**The Member-Secretary**

**Letter No. C3(S)/1374/2016****Dated : 27.03.2016**

**Sub:** CMDA – Area Plans Unit – MSB (South) Division - Planning Permission Application for the construction of Basement floor + Stilt floor + 11 Floors - Residential Multi-Storeyed Building with 22 dwelling units at Door No. 39, South Canal Bank Road, Raja Annamalaipuram, Mylapore, Chennai – 28, comprised in R.S.No. 4310/4, Block No. 96 and R.S.No.4569/16, Block No.100 of Mylapore village, Chennai – DC advice Sent – Reg.

FSI ACHIEVED = 1300.96/547.27 = 2.37

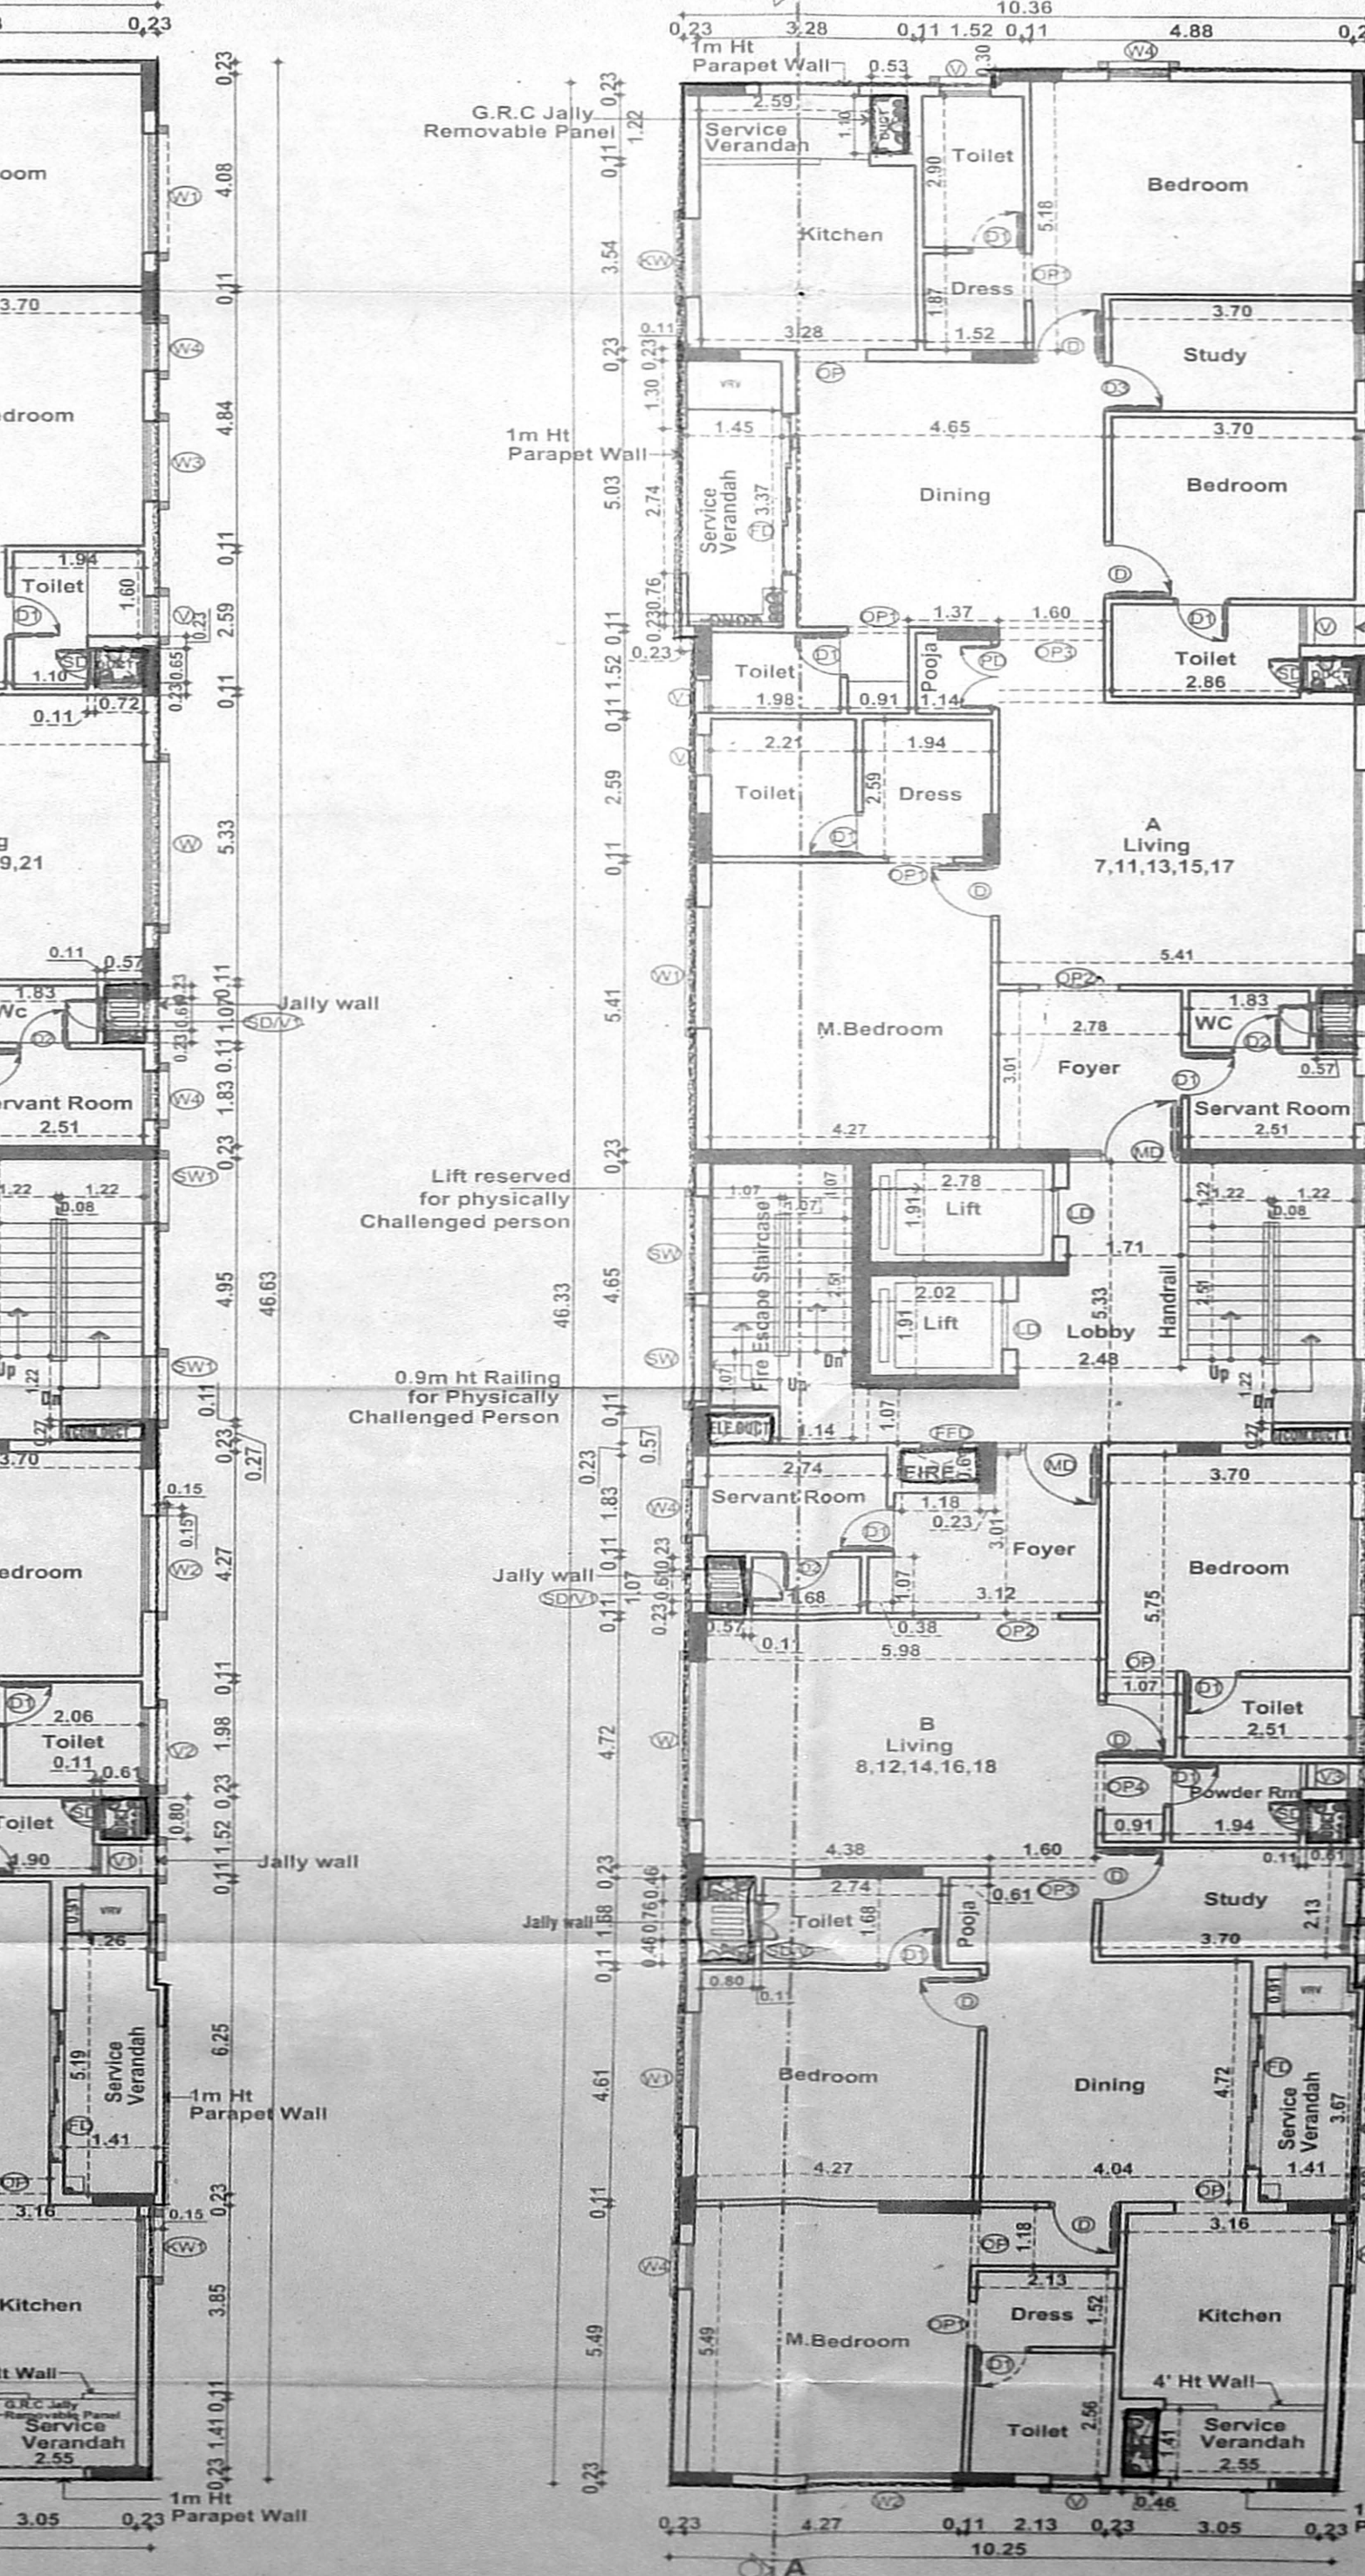
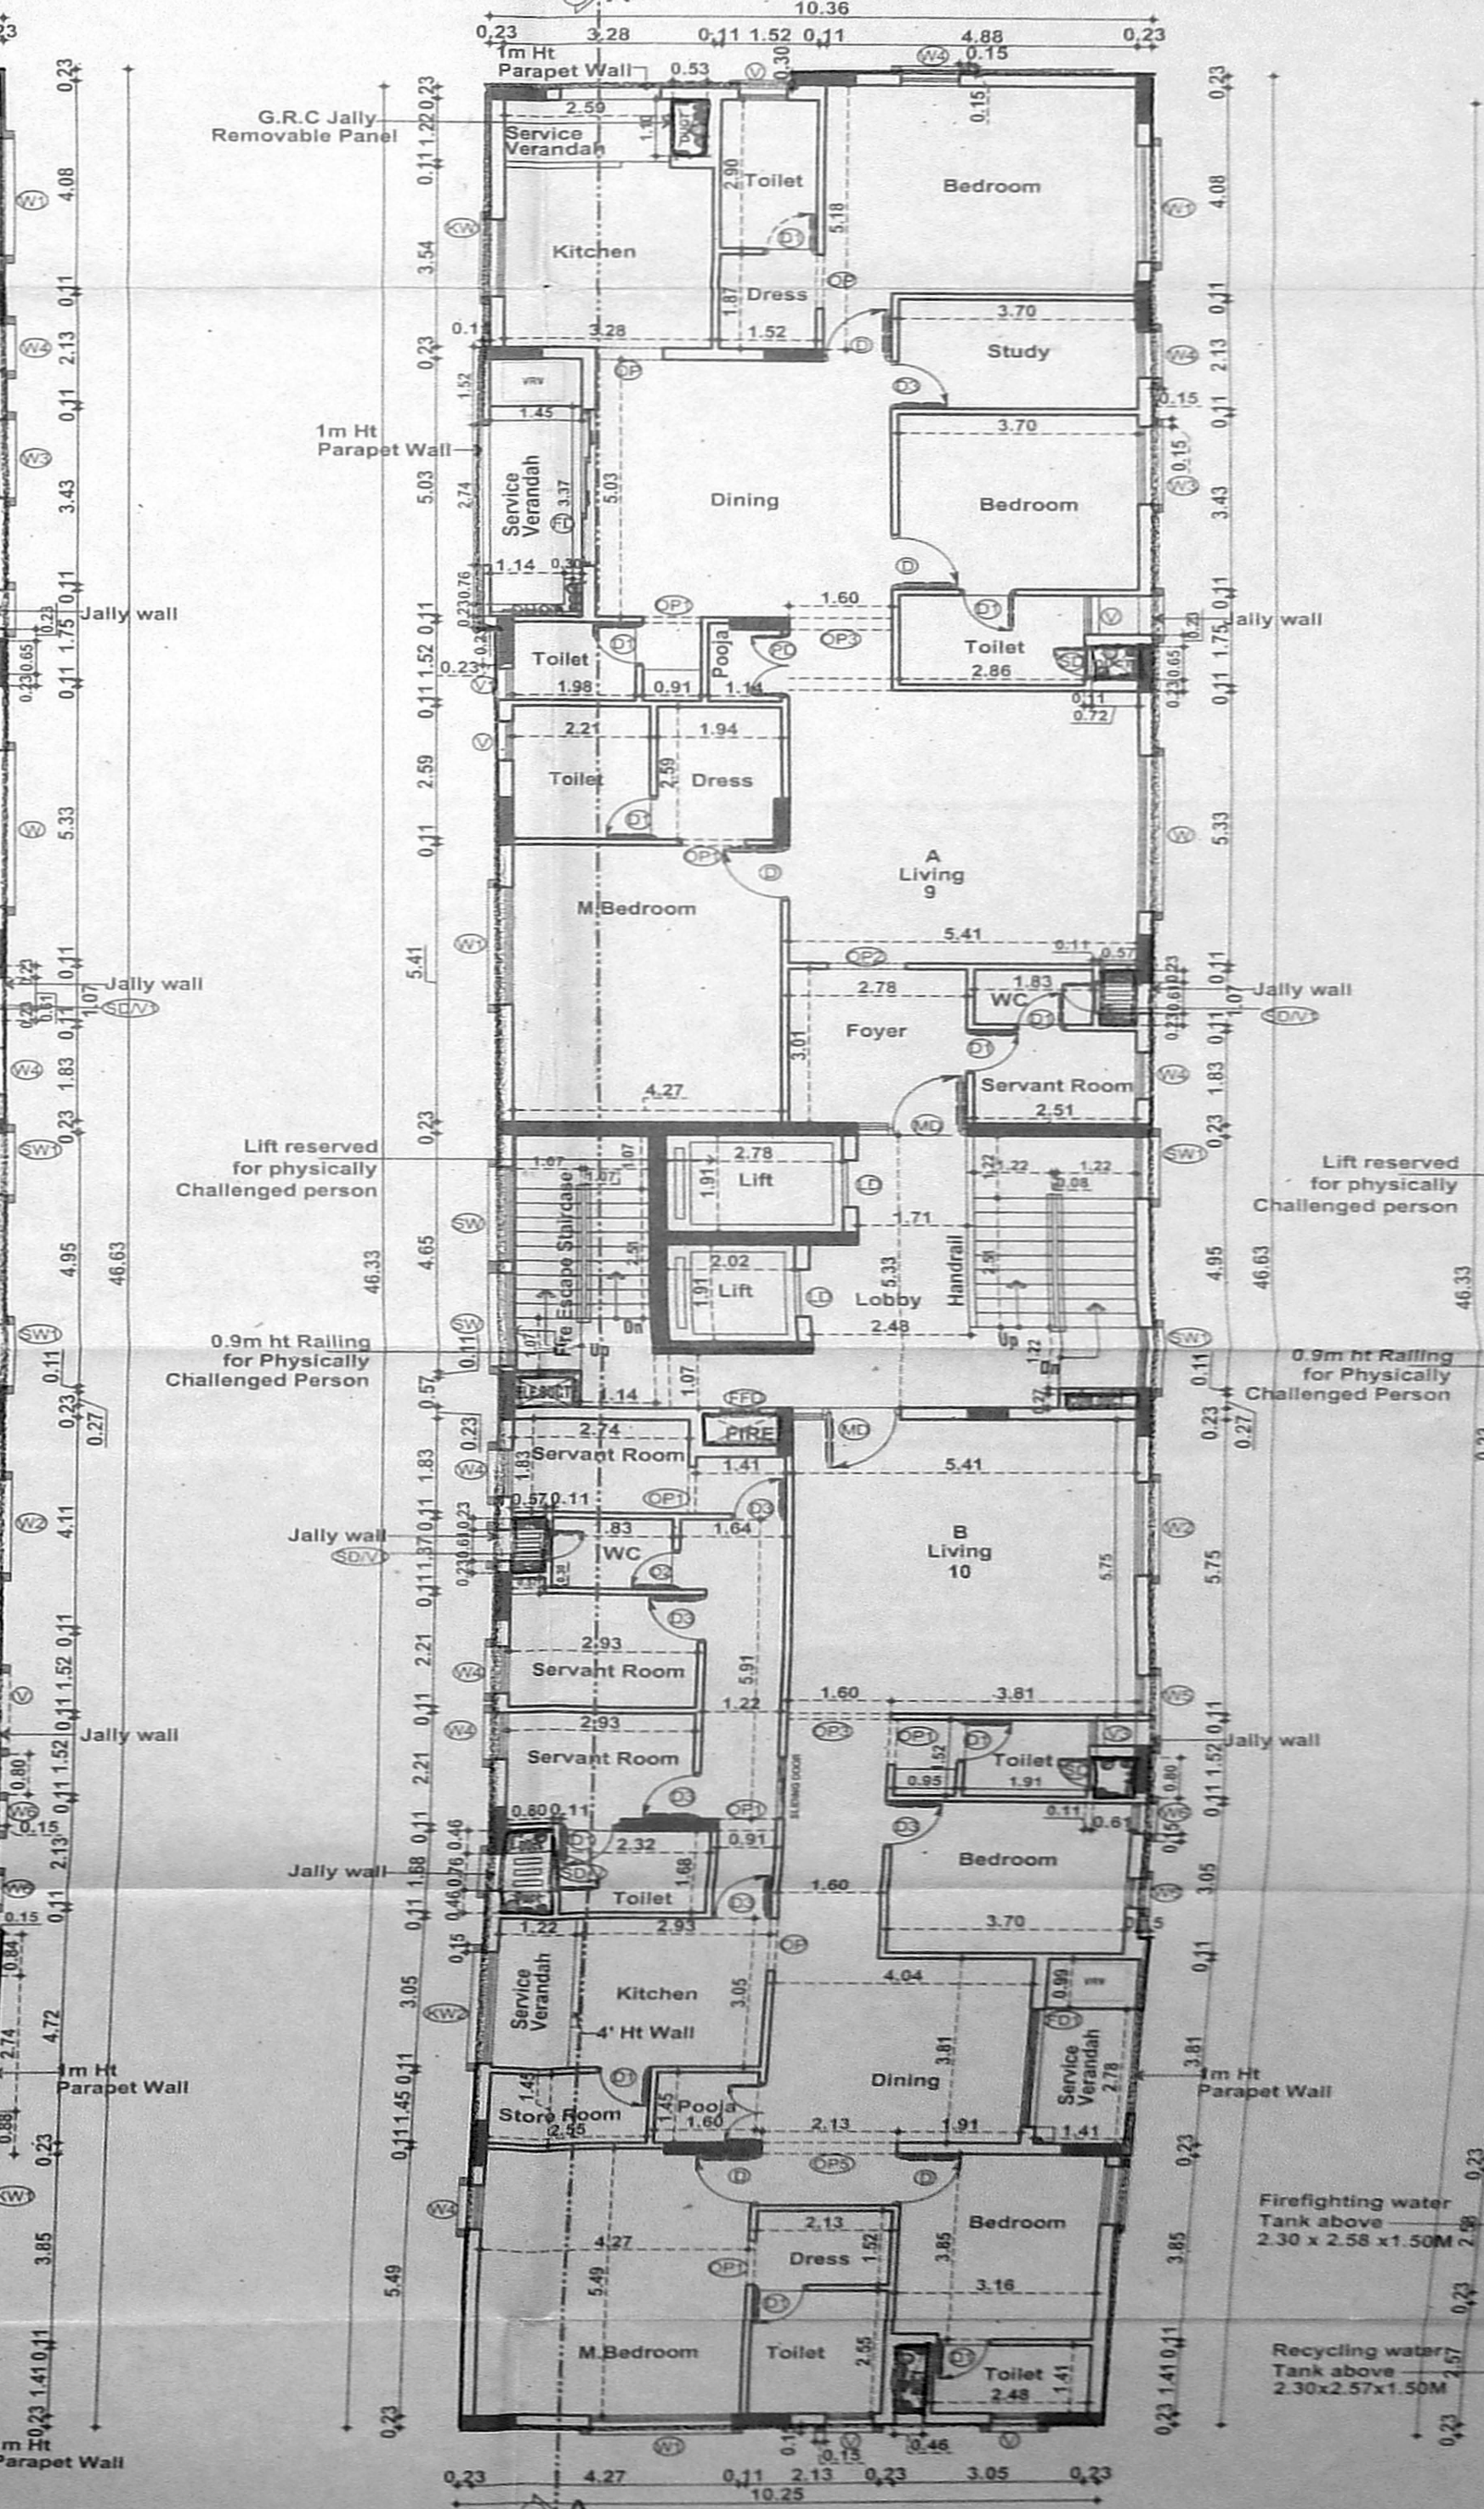
- (i) DG located at setback space is not permissible and hence the same is to be re-located either in Stilt floor or in Basement floor.
- (ii) All set in balconies and Utility are to be re-named as Service verandah provided with 1.0m height parapet wall/handrail and plumbing point.
- (iii) Electrical room is to be re-named as Electrical meter room.
- (iv) UG Sump for Rain water collection & Re-cycled Sullage water are to be provided.
- (v) The height of parapet is to be restricted to 1.0m at Terrace floor.
- (vi) Clear height of Basement floor and Stilt floor are to be mentioned in Cross section plan.
- (vii) As on site dimension and road width are to be shown tallying with inspection plan.
- (viii) Area statement to be corrected as per actual calculation.
- (ix) Sheet numbers are to shown as 1/3, 2/3 and 3/3.

(x) Transformer yard & security cabin are to be located after leaving min. required setback of 7.20m

(xi) Gym intended for human habitation proposed in Basement floor without ventilation is not permissible.
